Application Ref:	2025/0993			 Ribble Valley Borough Council www.ribblevalley.gov.uk				
Date Inspected:	22/01/2026	Site Notice:	22/01/2026					
Officer:	EP							
DELEGATED ITEM FILE REPORT:					REFUSAL

Development Description:	Advertisement Consent for the erection of two marketing sale boards on either side of the site access measuring 3.1m high and 1.35m wide and 0.12m deep.
Site Address/Location:	Land South of Accrington Road Whalley

PROJECT TITLE	
Accrington Road Whalley	
DRAWING TITLE	
PLANNING Proposed Marketing Signage	
DRAWING NUMBER	REVISION
015/ADV-S/01	A
DATE	SCALE
12/25	1:1250@A3

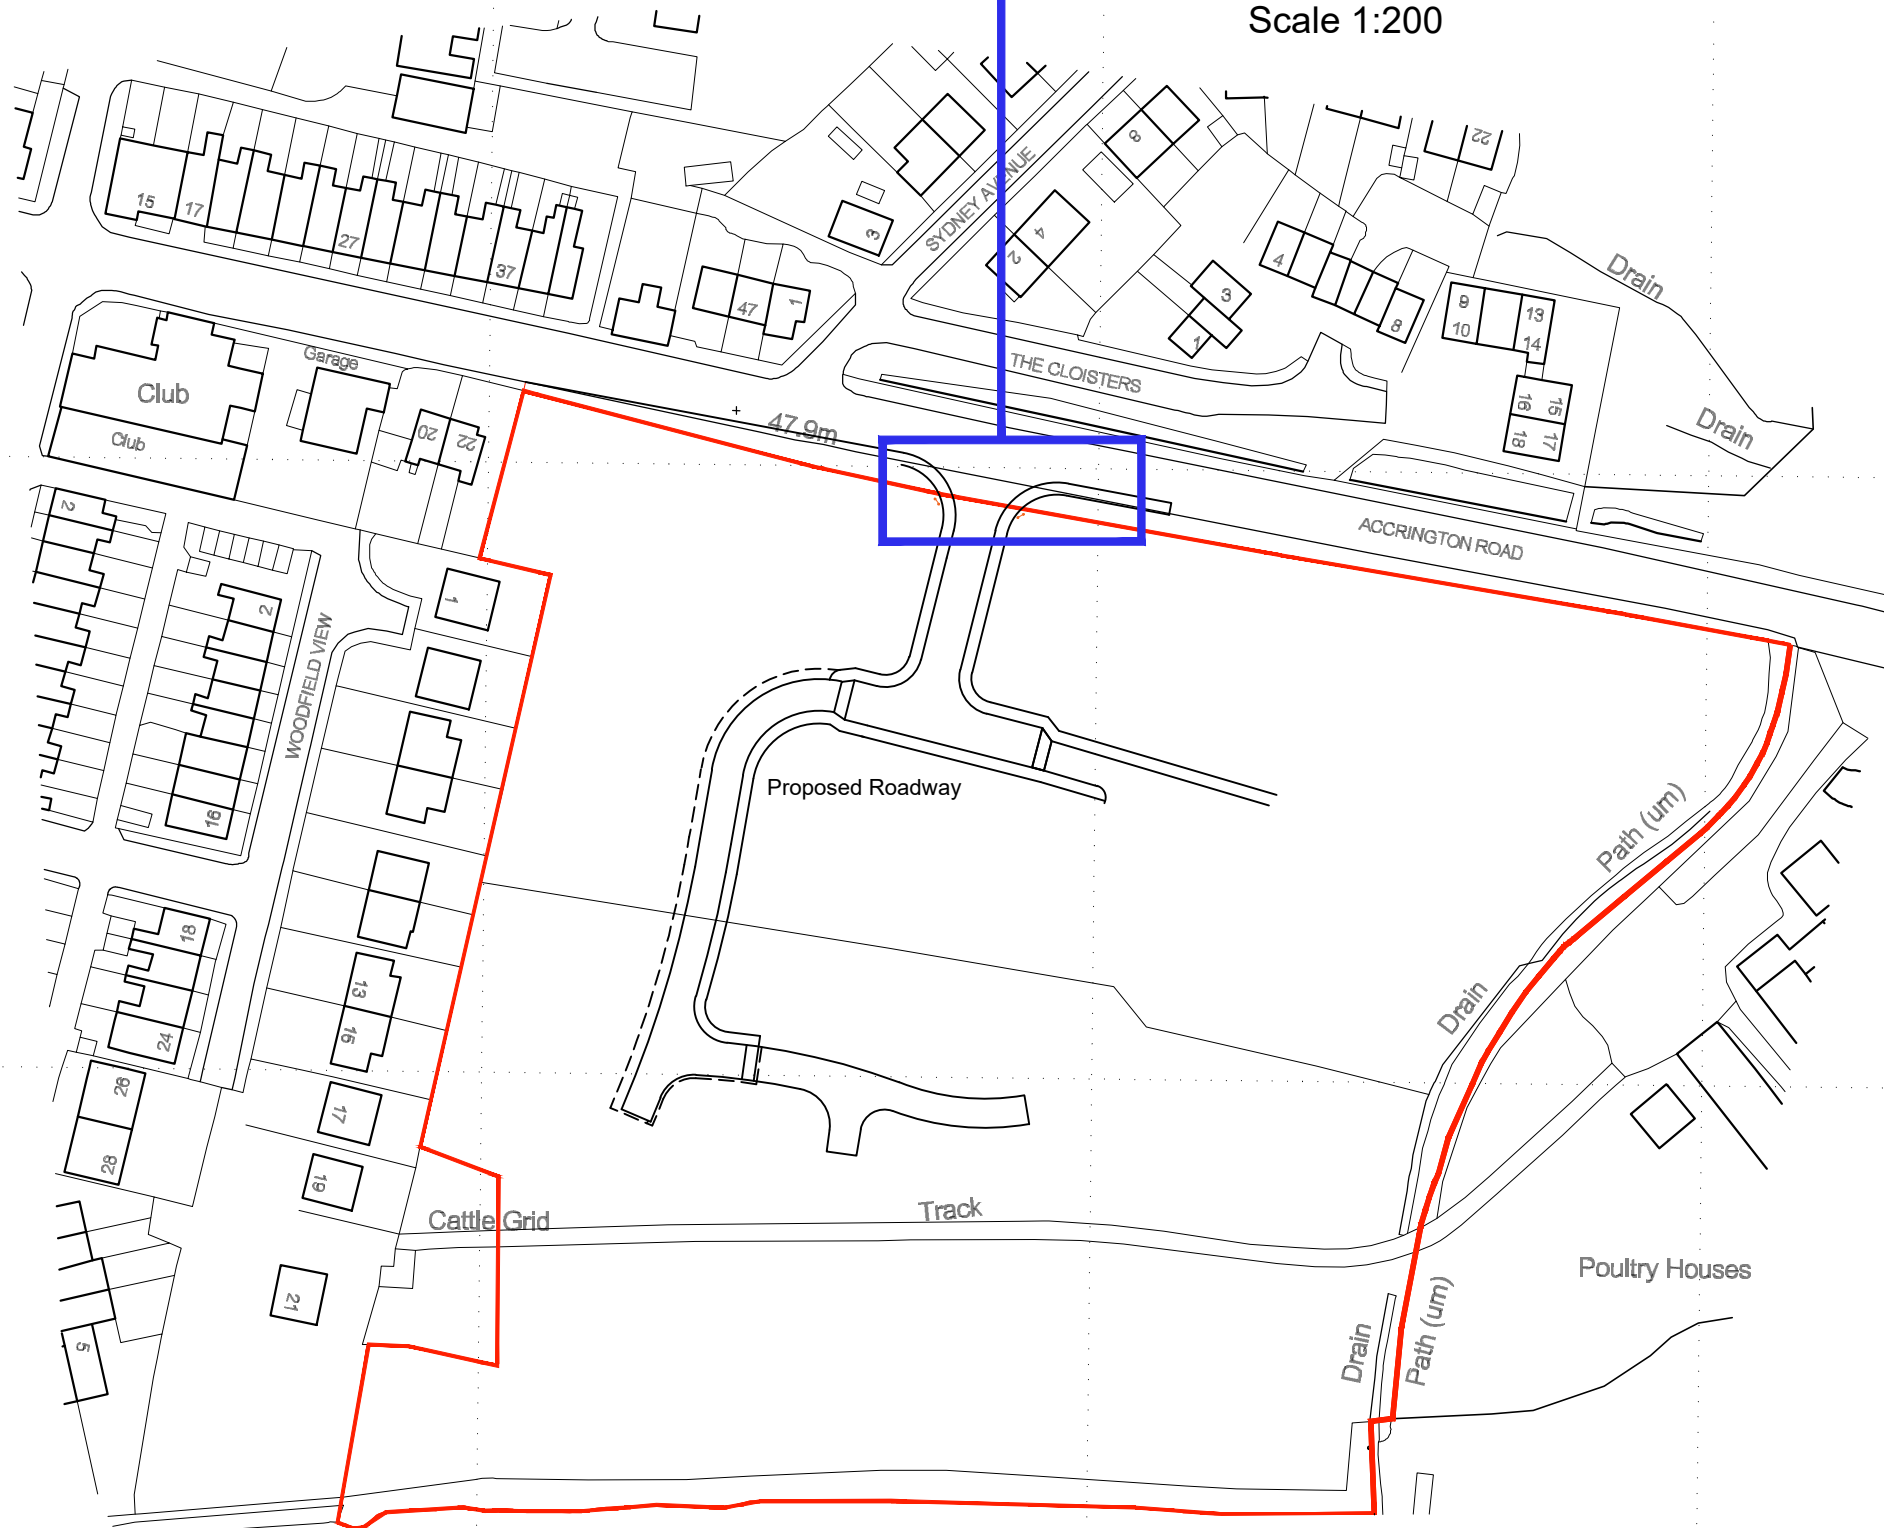
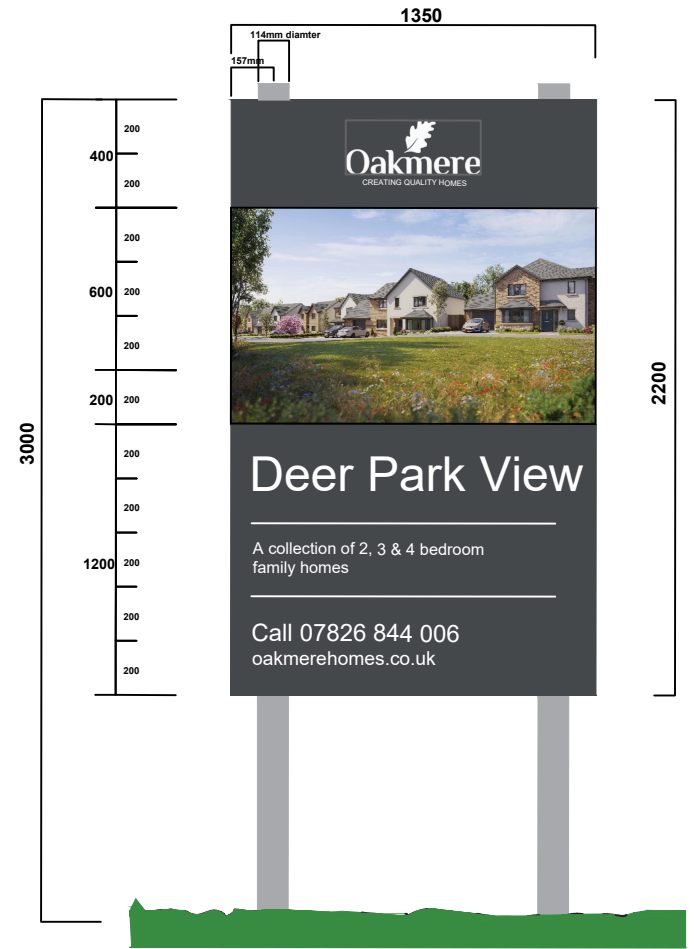
The proposed signage will be located immediately adjacent to Accrington Road and will therefore be readily visible from within the public realm. In respect of scale, the signs will each measure 1.35m in width, with a height of 2.2m or 3m inclusive of the mount. The scale is substantial given the two boards are located immediately adjacent to one another and resulting in the creation of development that would be overly prominent and dominate the street scene. Their visual prominence would be exacerbated by virtue of the dark colour palette which will be seen in contrast within the existing landscaping and built form found within the existing street scene. This is particularly unacceptable given the signage would be seen within the context of the adjacent conservation area and subsequently effect its setting.

With the above in mind, it is considered that the proposed signage would be an inappropriate and unacceptable addition to the existing street scene by virtue of its visibility and scale which would be largely unsympathetic to and detract from the area’s features and immediately adjacent heritage asset, Whalley Conservation Area.

The proposed signage, by virtue of its siting, high level of visibility from the public realm, and scale results in a discordant, unsympathetic and incongruous form of development which results in significant detriment to the character and visual amenities of the area, undermining the inherent character of the streetscene and proving injurious to the character and visual amenities of the adjacent Whalley Conservation Area. As such the proposal is considered to be in direct significant conflict with Key Statement EN5 and Policies DMG1 and DME4 of the Ribble Valley Core Strategy.
